STATE OF WASHINGTON  
DEPARTMENT OF ECOLOGY

Re: ACU-19-00001

Thank you for the opportunity to comment during the optional determination of nonsignificance process for the ATT Teanaway Cell Tower project, proposed by Washington Department of Natural Resources. We have reviewed the documents and have the following comments.

**SHEET TITLE**  
 ENLARGED SITE PLAN

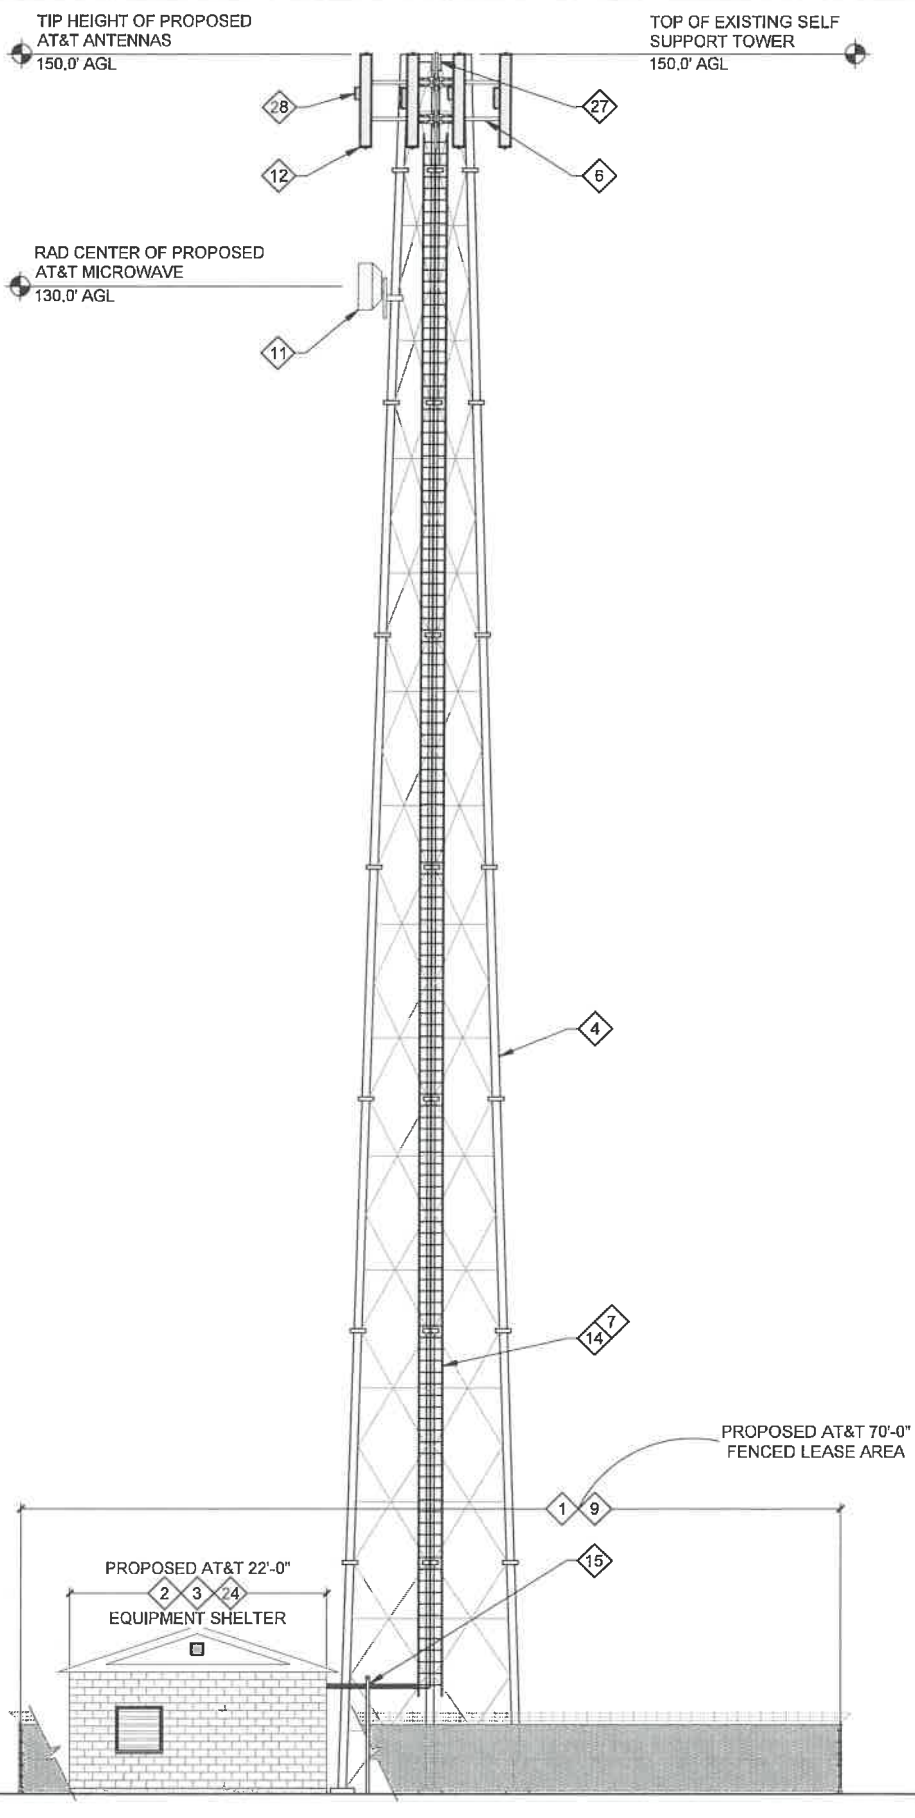
This proposal does not specify whether it includes an emergency generator(s). If it does, note that stationary emergency internal combustion engines (emergency generators) with aggregate brake horsepower greater than 500 brake horsepower require a preconstruction air quality permit. For information regarding air permit applicability and/or process, please contact **Ryan Vicente** at (509) 454-7899 or [ryan.vicente@ecy.wa.gov](mailto:ryan.vicente@ecy.wa.gov).
